City of Portland, Maine - Building or Use Permit Application
 389 Congress Street, 04101 Tel: (207) 874-8703, Fax: (207) 874-8716

| Permit No: 06-0880 | Issue Date: | CBL: 143 A016001 |

| Location of Construction: 51 TREMAINE ST | Owner Name: ANDERSON CHRISTINA M | Owner Address: 51 TREMAINE ST | Phone: |

| Proposed Project Description: Demolish old garage & rebuild in exact footprint & demolish existing wood walkway between the garage & house and replace the 5' x 5' deck/entry at rear of house. (Demo permit #06-1232) | | FIRE DEPT: <input type="checkbox"/> Approved <input type="checkbox"/> Denied | INSPECTION: Use Group: Type | |

Scale 1"=20'	Approved By	Drawn By TC
Date 7-24-06	PHOT R.M.H	Revised
Drawn For ANDERSON		
Location 51 TREMAIN ST. PORTLAND		Drawing # 8

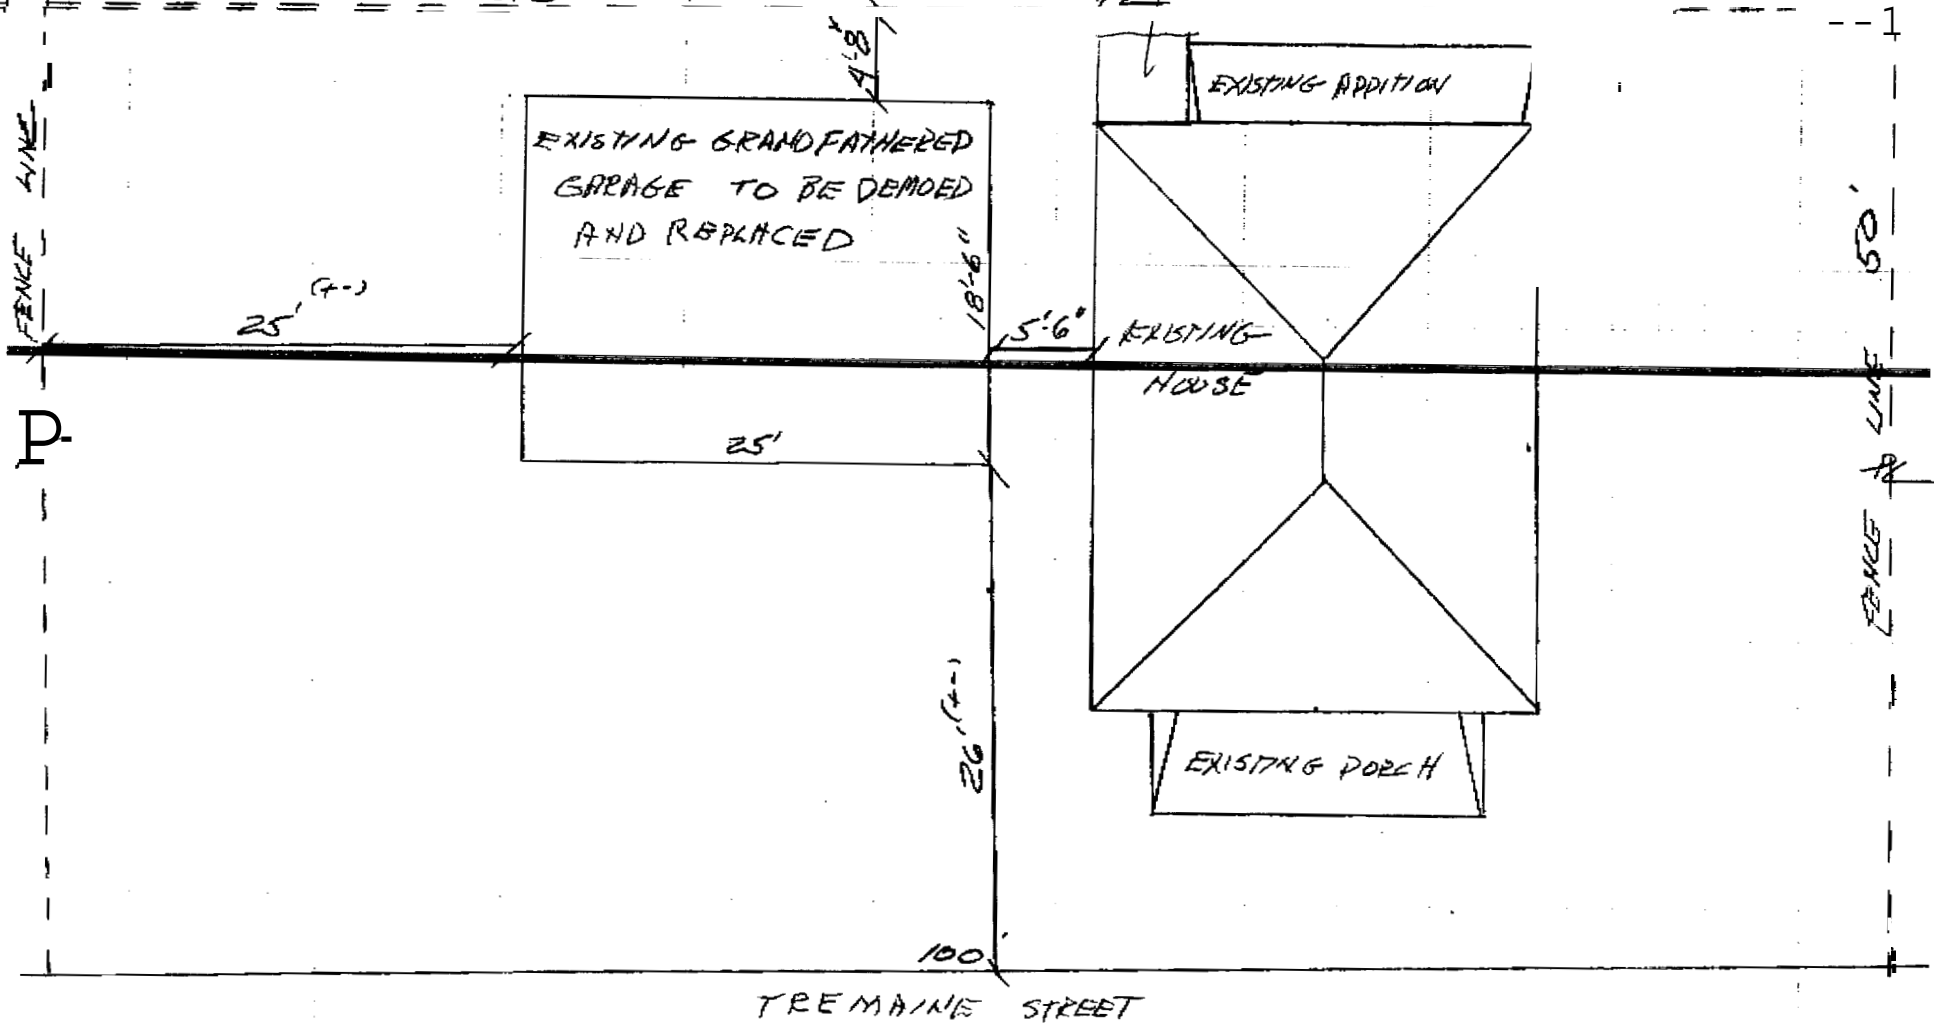
8/22/06-amachado: Called Tammy Bilodeau at Maine-wide Construction. Plans show a wood walkway being removed and a landing off the addition in the back that are not on the plot plan. Are these part of the permit or do they already exist?

7/31/06-amachado: Still on Hold. Tammy called and needed the names of the abutters for the demolition permit which I gave her. I also reminded her that we needed a more complete plot plan.

- 1) This permit is being approved on the basis of plans submitted. Any deviations shall require a separate approval before starting that work.
- 2) This permit is being issued with the understanding that the new garage will be built in the existing footprint of the old garage and the new rear deck/entry will also be within the existing footprint.
- 3) This property shall remain a single family dwelling. Any change of use shall require a separate permit application for review and approval.
